KITTITAS COUNTY FIRE MARSHAL'S OFFICE

September 19, 2011

Re: Marchel (BL-11-00020)

BOUNDARY LINE ADJUSTMENT  
PREPARED FOR  
ARVIN MARCHEL  
A PORTION OF THE WEST 1/2 OF SECTION 14,  
TOWNSHIP 17 NORTH, RANGE 20 EAST, W.M.

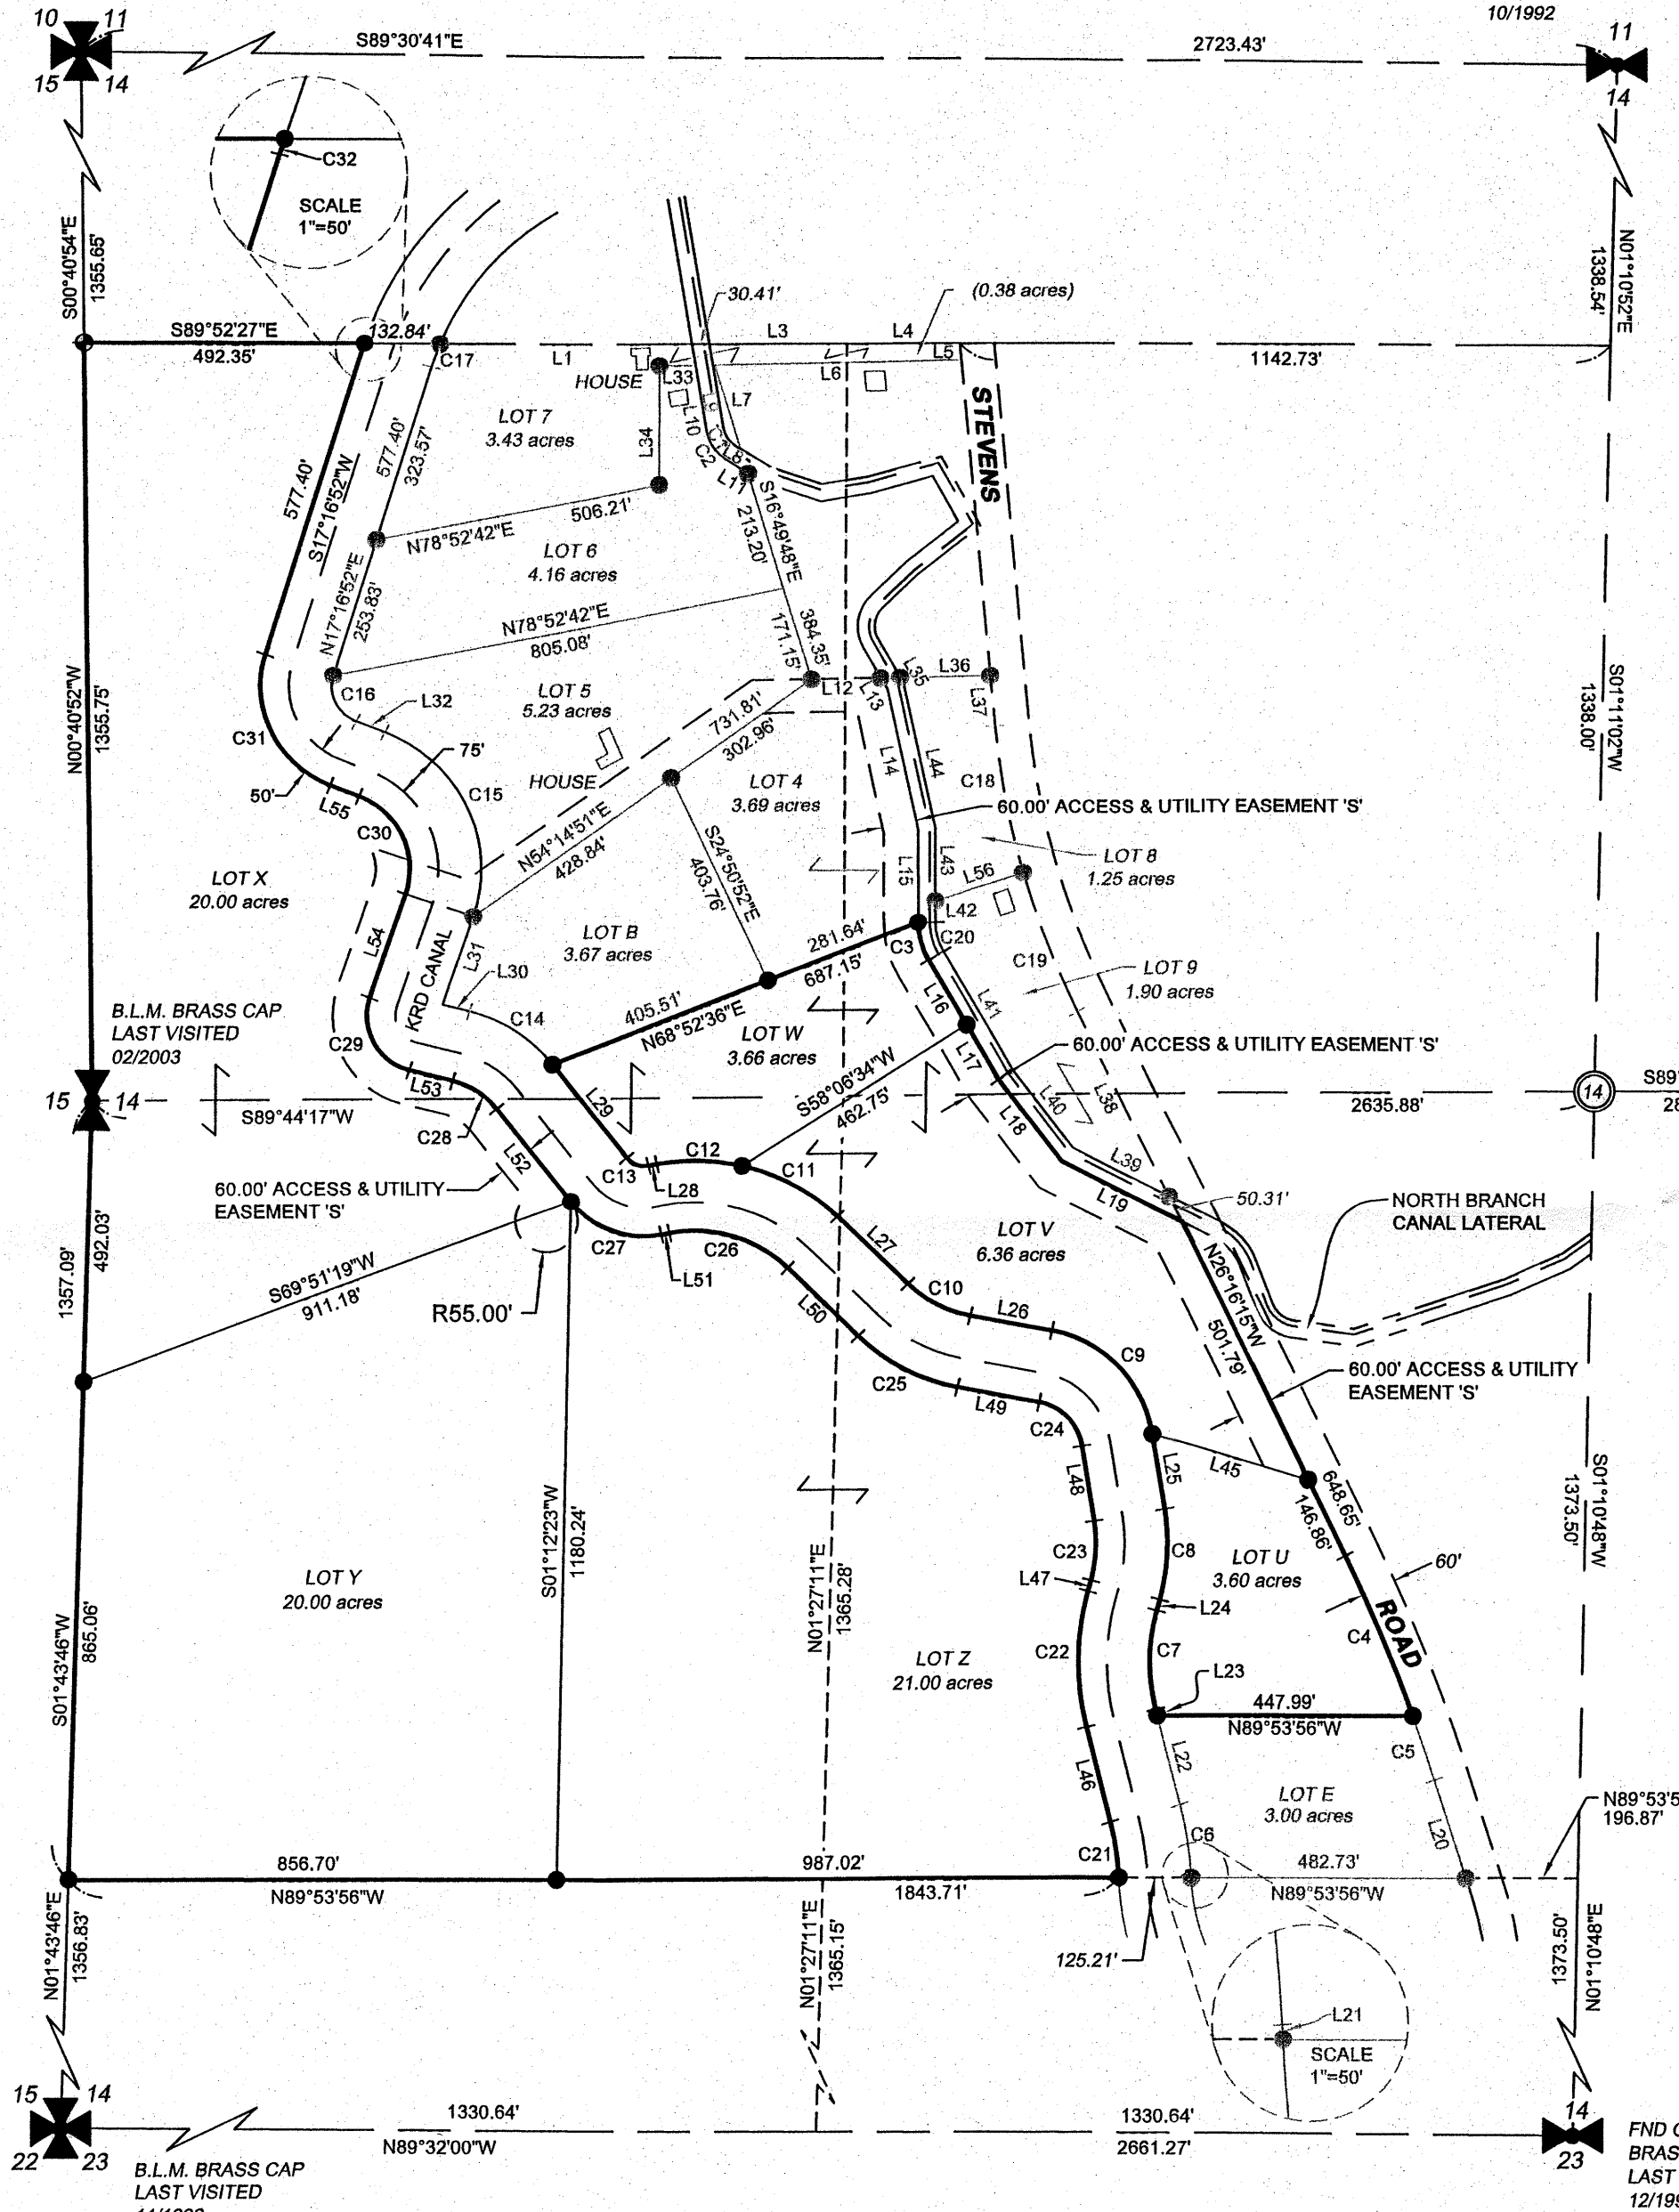
- Ensure that boundary line adjustments do not infringe upon existing structures, to include propane tanks, etc.
- Creation of any additional roads or access must comply with the International Fire Code.
- All future development must comply with the International Fire Code.
